**Our ref:** RA/2024/147502/05-L01  
**Your ref:** 2024/0580

**Date:** 28 November 2025

**HYBRID PLANNING APPLICATION COMPRISING A) FULL PLANNING APPLICATION FOR 250NO DWELLINGS INCLUDING 2, 2.5, AND 3 STOREY HOUSES TOGETHER WITH ATTENUATION BASIN AND TEMPORARY ACCESS ROUTE, LANDSCAPING AND ASSOCIATED WORKS AT AREA 1 AND B) OUTLINE PLANNING APPLICATION WITH ALL MATTERS RESERVED FOR UP TO 200NO. DWELLINGS ON AREA 2 (AMENDED RED LINE BOUNDARY, DESCRIPTION AND PLANS). LAND SOUTH OF DONCASTER ROAD AND ADJACENT TO STRAWBRIDGES GARDEN CENTRE, DARFIELD, BARNSELY, S72 5EZ**

In the absence of an adequate flood risk assessment (FRA) we object to this application and recommend that planning permission is refused.

Fig 3 – Flood Zone Extents Adjacent Proposed Detention Basin

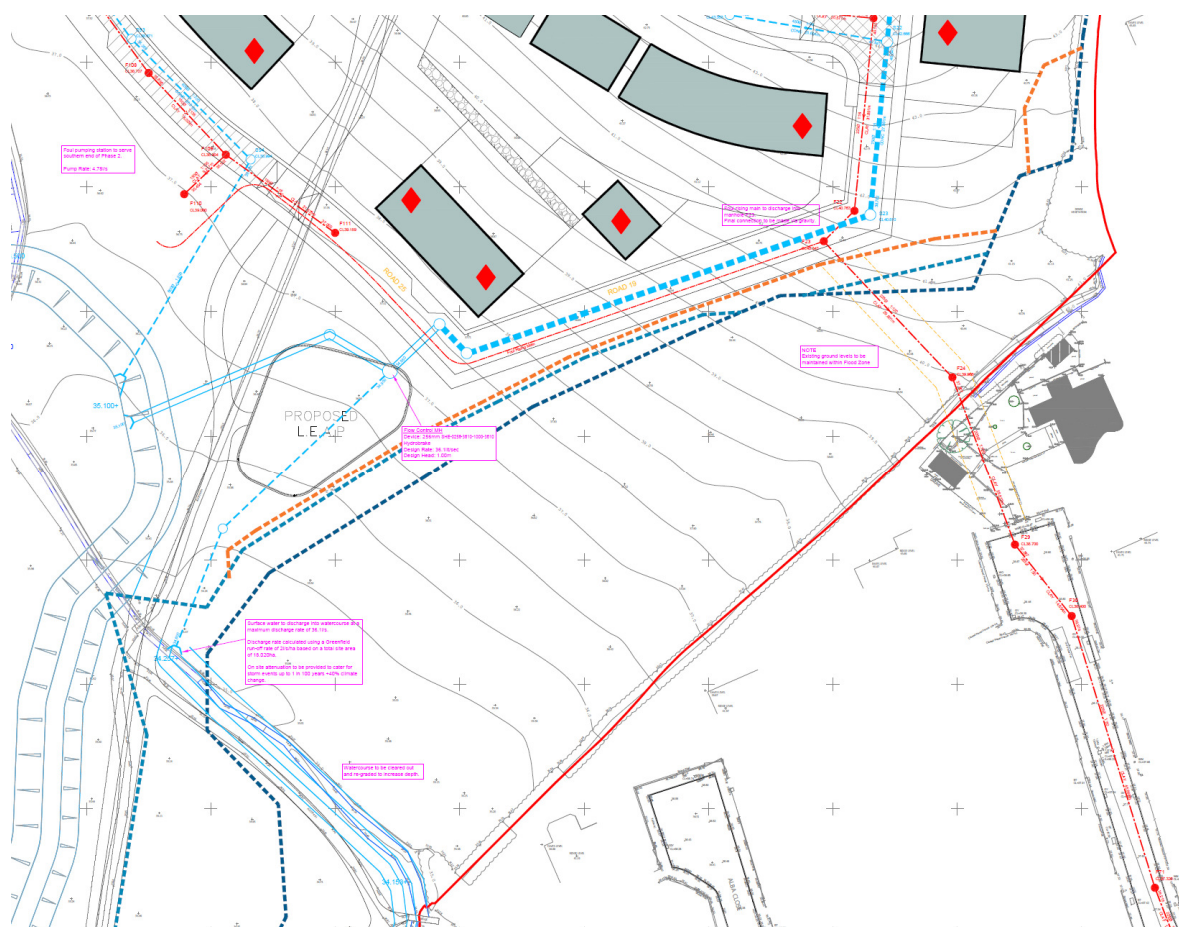
With regard to our comments on the proposed basin, our concerns aren't around the basin's capacity to contain surface water, but actually, that we don't consider that enough detail has been provided on the basin design, to understand whether it could impact fluvial flood risk, for instance by incorporating raised embankments or reprofiling within the fluvial design floodplain.

It should be noted that a surface water detention basin can't be considered as providing any storage volume for fluvial flooding as it has to be assumed that it is full, from surface water.

- Finished floor levels no lower than 600mm above the designed flood level.
- Ensure the proposed development does not increase offsite flood risk by displacing flood water during fluvial flood events.
- Evidence the proposed watercourse rerouting and basin development do not increase offsite fluvial flood risk by displacing or re-routing flood water.
- Demonstrate that site users have a safe means of access and egress up to and including the fluvial design flood event.
